Description: To provide production facilities for the manufacture of pizzas, together with associated amenities and facilities

Location: Sluice Road
Holbeach St Marks

Amendment: Reduce size and amend design of reception area at western end of pizza building

**TOWN AND COUNTRY PLANNING ACT 1990
NOTICE OF ACCEPTANCE OF AMENDMENT**

DRAWING
EXISTING AMENITY
GROUND FLOOR PLAN

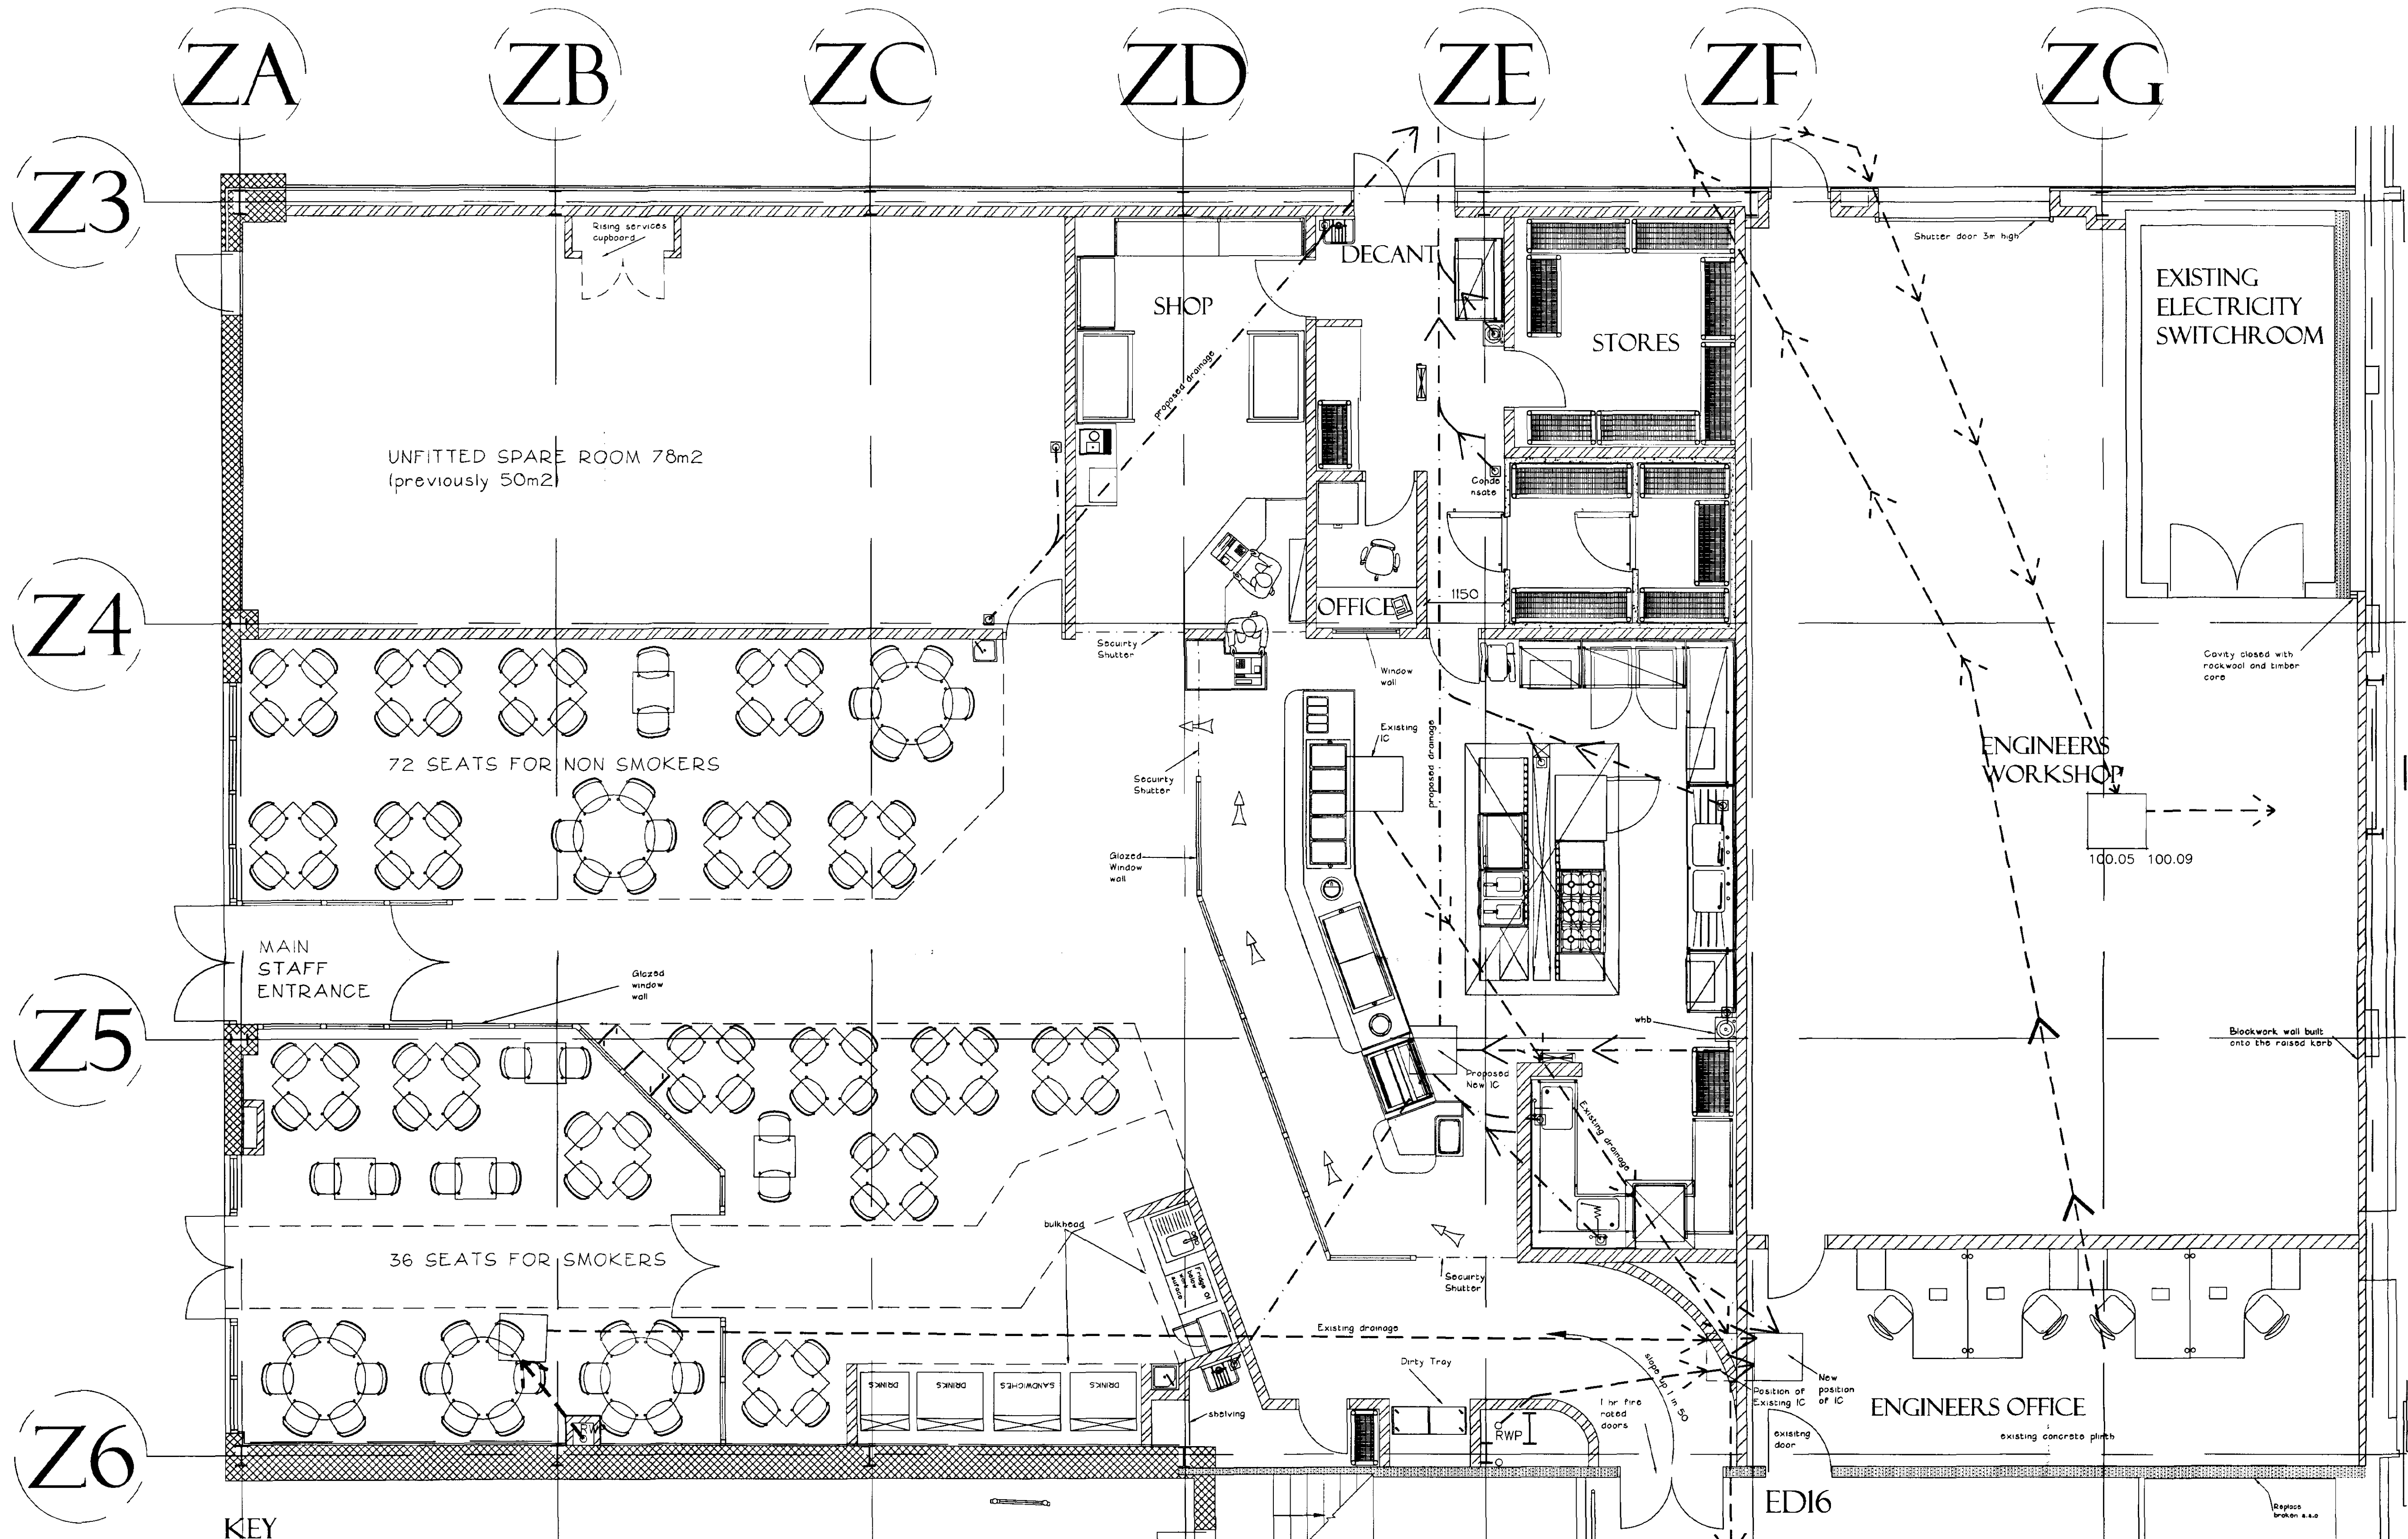
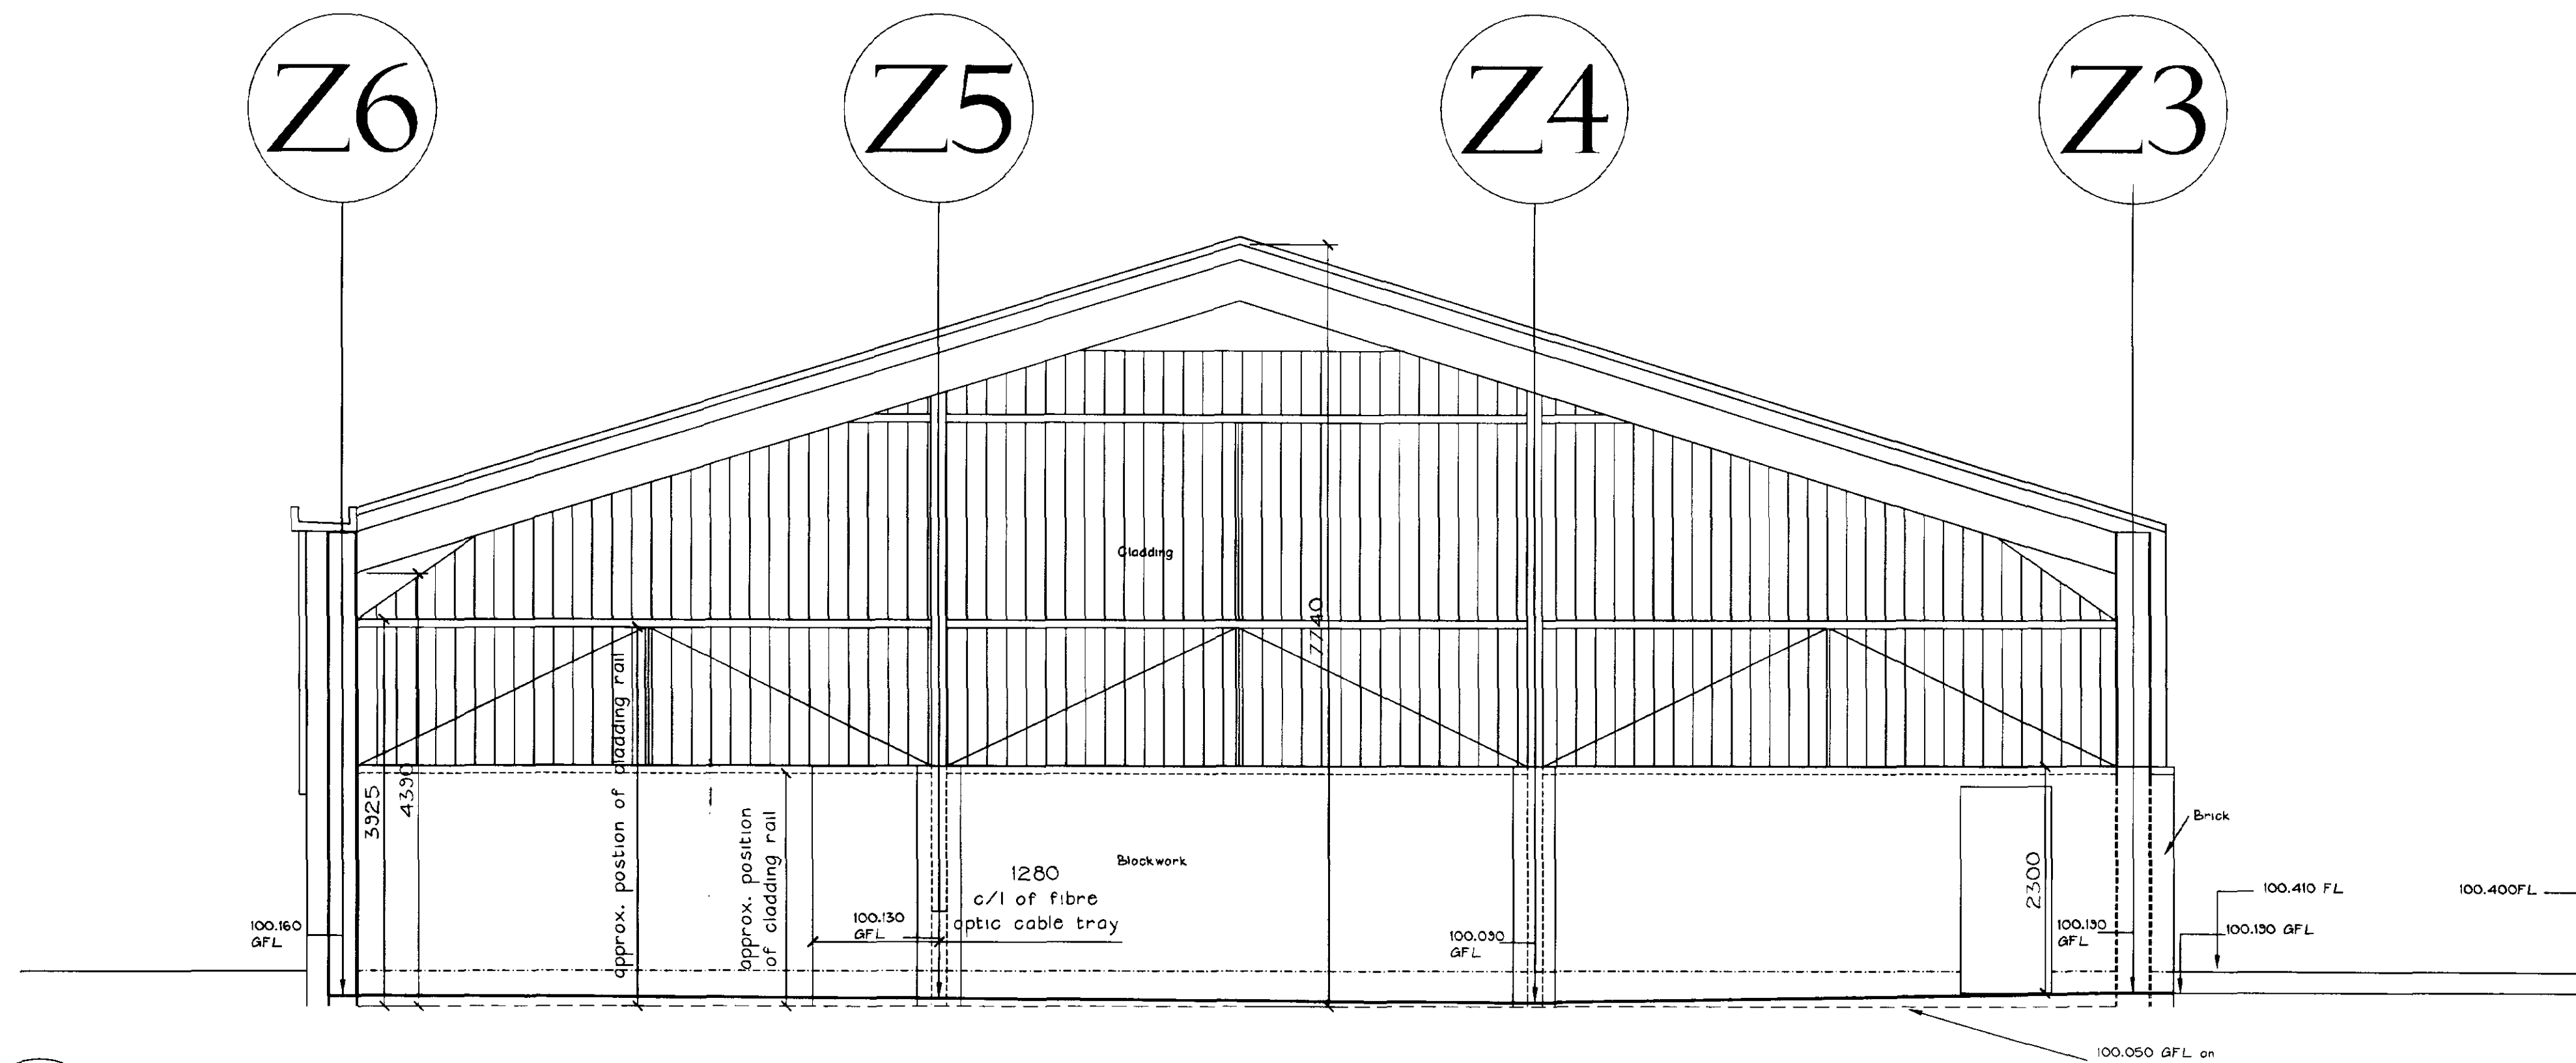
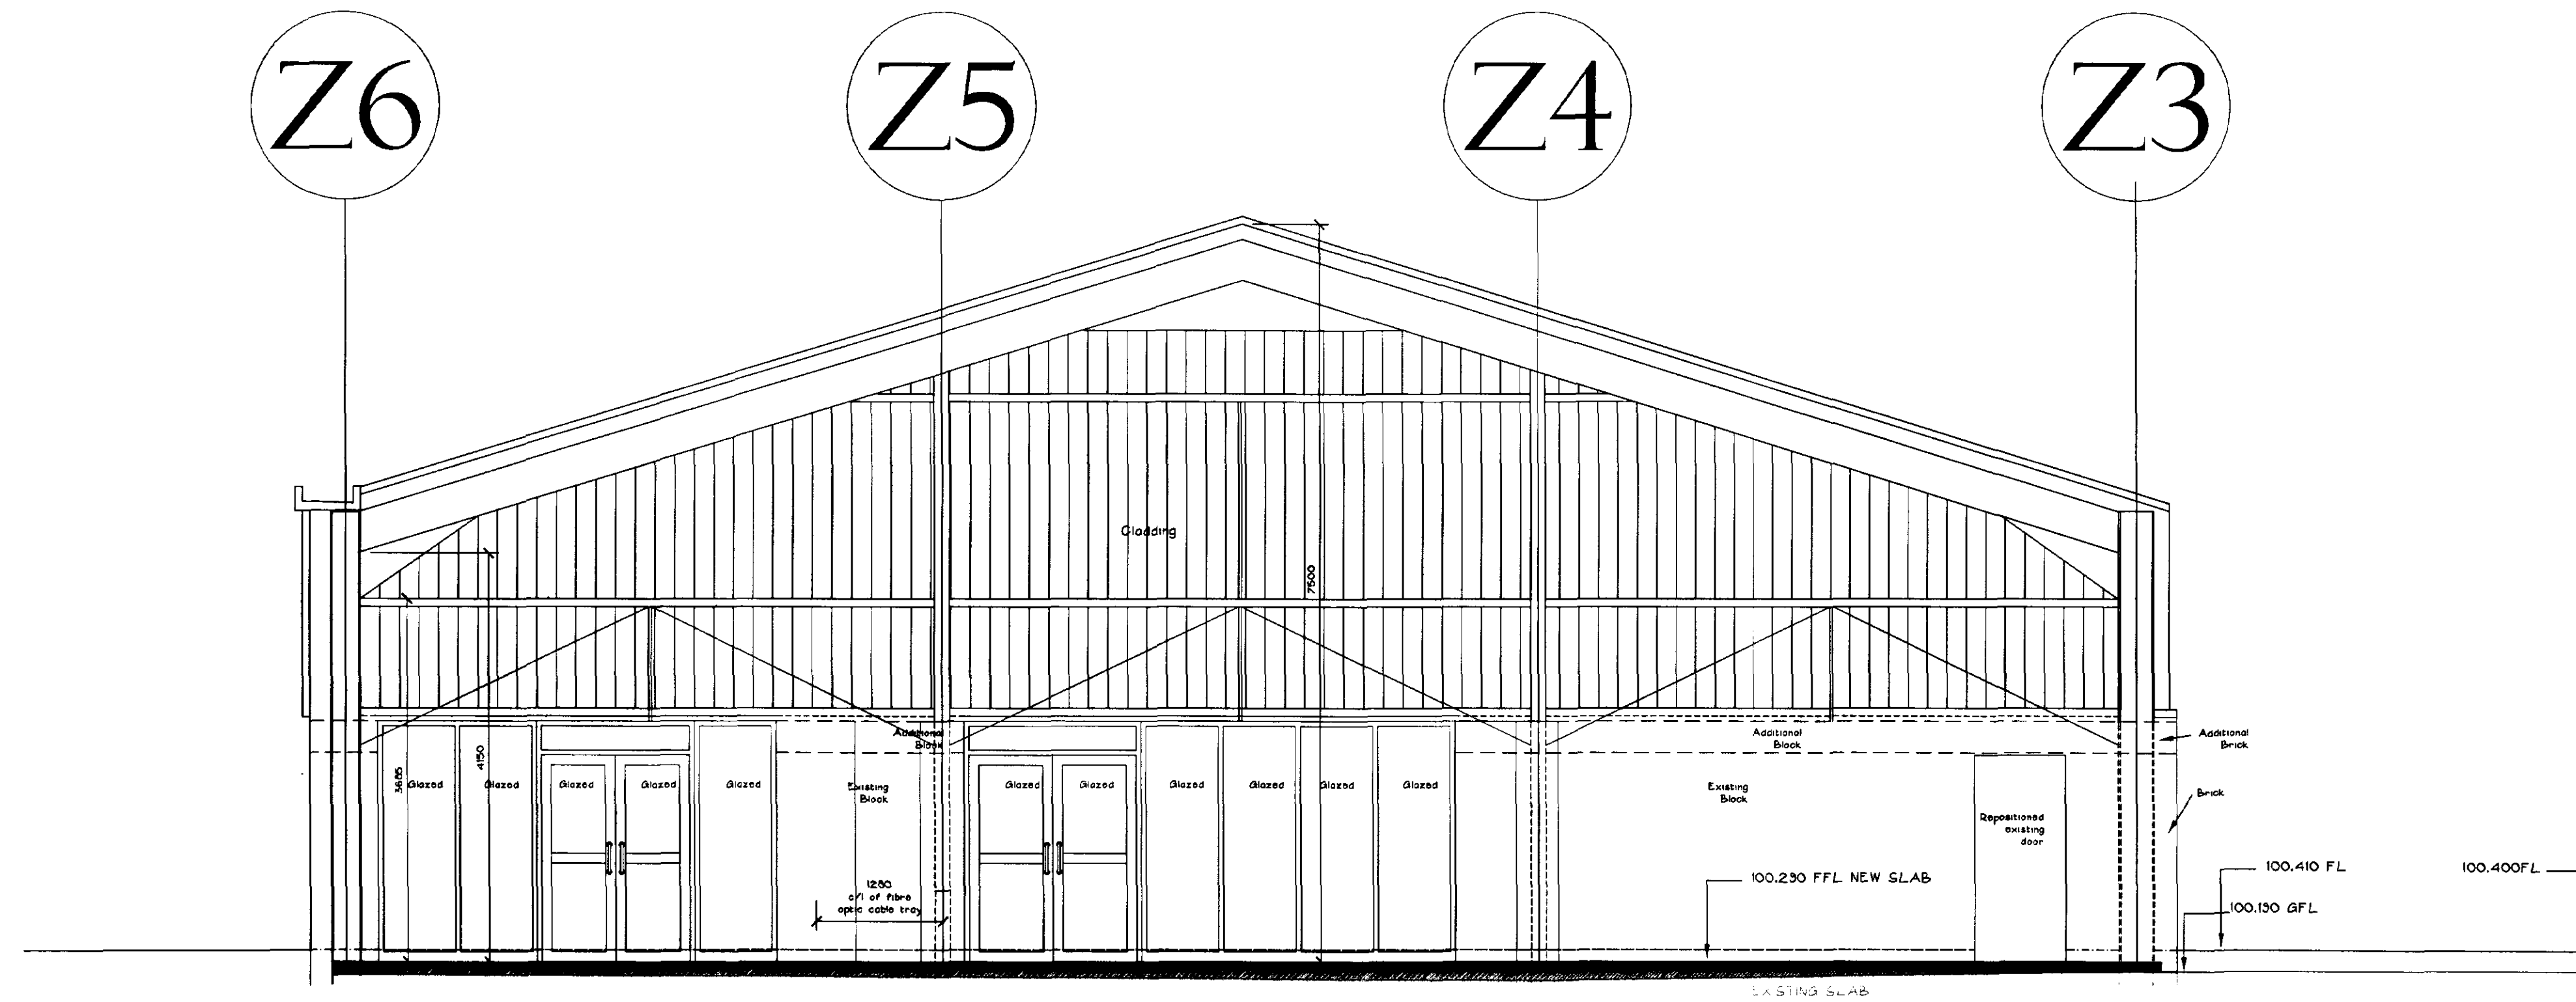
Amendment: Amend canteen & amenity reception area (dwg nos. 03-27/499, /500, /501B, /550, /551, /552 & /553)

Further to your recent discussion with Jo Willis I enclose details showing our proposals for the Canteen and Amenity Reception area in existing buildings at Geest, Holbeach.

(03 - 27)	499	Site Plan
	500	Existing Amenity Ground Floor Plan
	501B	Proposed Amenity Ground Floor Plan
	550	Existing Plan For Workshop, Canteen and Shop
	551	Proposed Plan For Workshop, Canteen and Shop
	552	Existing Section and Elevations For Workshop, Canteen and Shop
	553	Proposed Section and Elevations For Workshop, Canteen and Shop

The amended details submitted in respect of the above proposal have now been considered and there are no objections to the amendment being implemented to the extent described above.
